PO/3/21/L

Peckhams Poling Street Poling BN18 9PT

Replacement of four timber windows on a 'like-for-like' basis, two vertical sliding sashes on the side (west) elevation and two casements on the rear (south) elevation

PECKHAMS, POLING STREET, POLING
Proposals 01

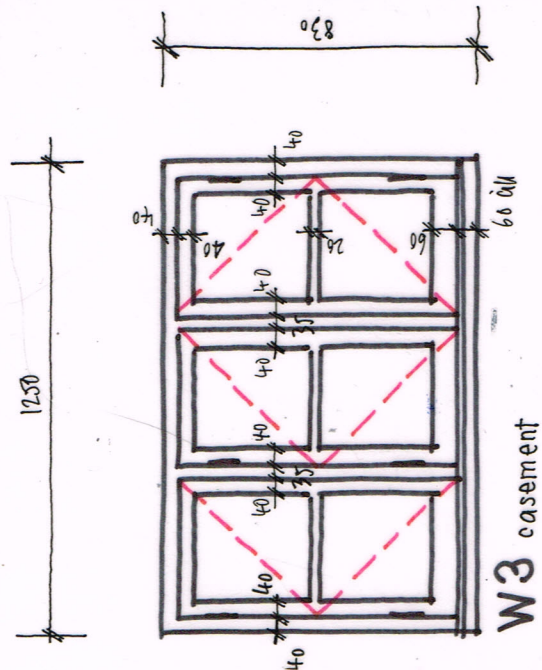
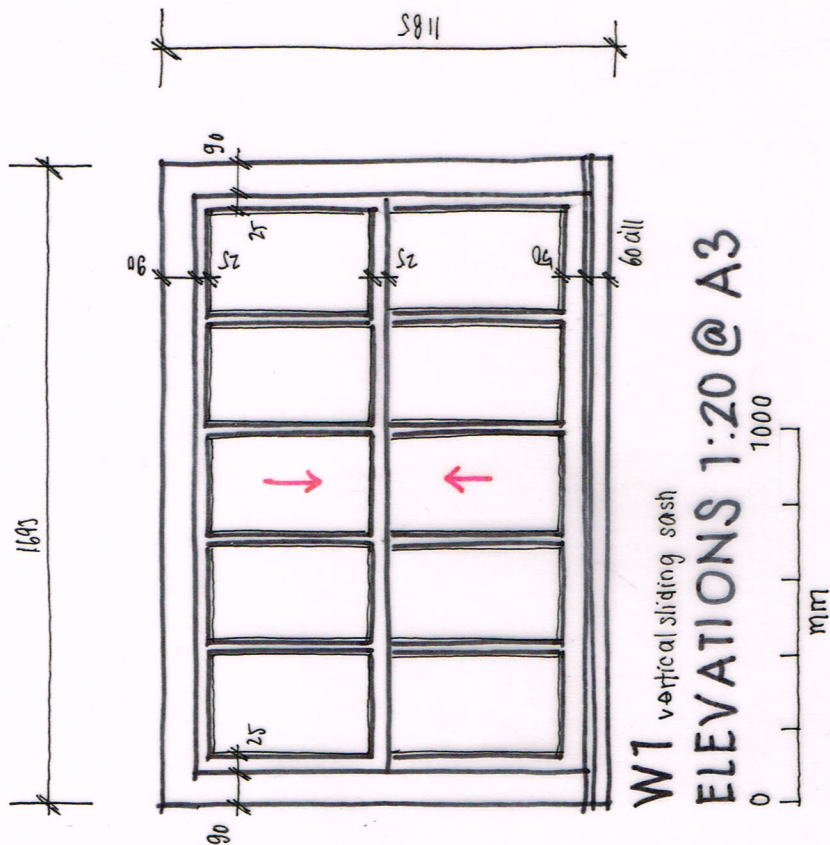
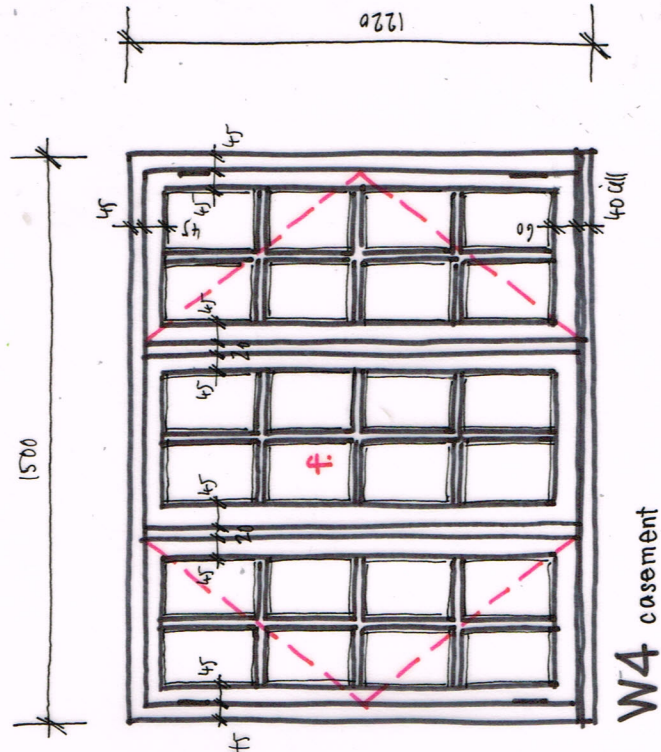
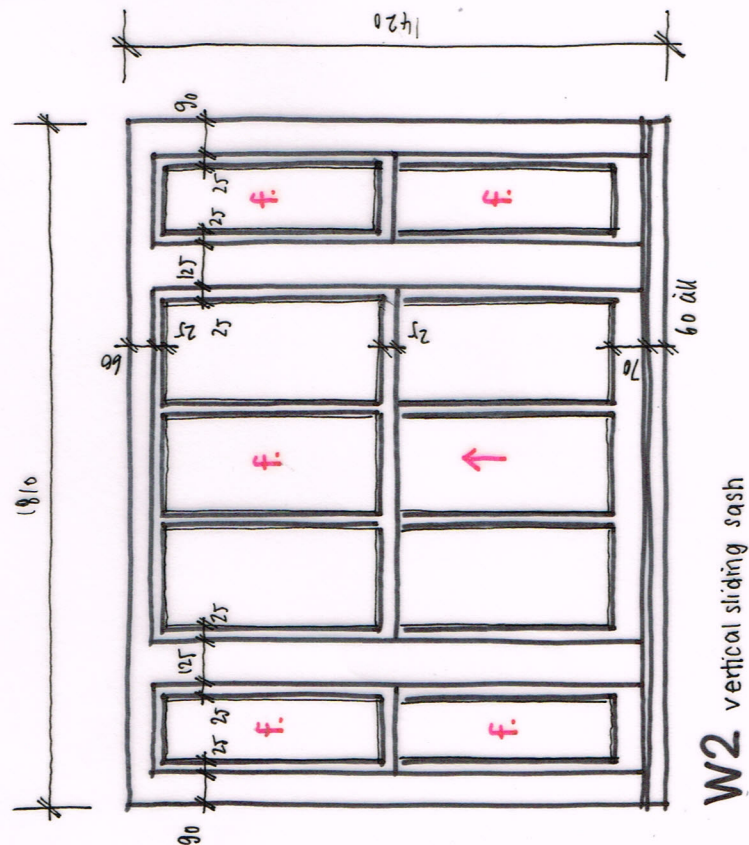
It is noted that the heritage statement identifies that the applicants consider that it is uneconomical to carry out further repairs to the defective windows and therefore more appropriate to carry to full replacement. However, it is not clear how the windows are defective, and what would make them beyond repair. Such information is normally helpful to justify their complete replacement.

The proposed glazing system is minimal and has been approved in other buildings in the district. However, they are not always appropriate in listed buildings and they can affect the appearance of the windows, especially details such as the size and style of the glazing bars (an increase in size would not be appropriate). In this case, the design of the windows would support their use, and I note that the application states that the windows will be replaced on a like for like basis. A section of the windows has not been provided, which means that it is not possible to understand if the glazed units would form a series of separate units or one with applied glazing bars. The latter would not be appropriate for a listed building or these windows. Details of the section/glazing bars could be provided to the LPA if you are minded to approve the application.
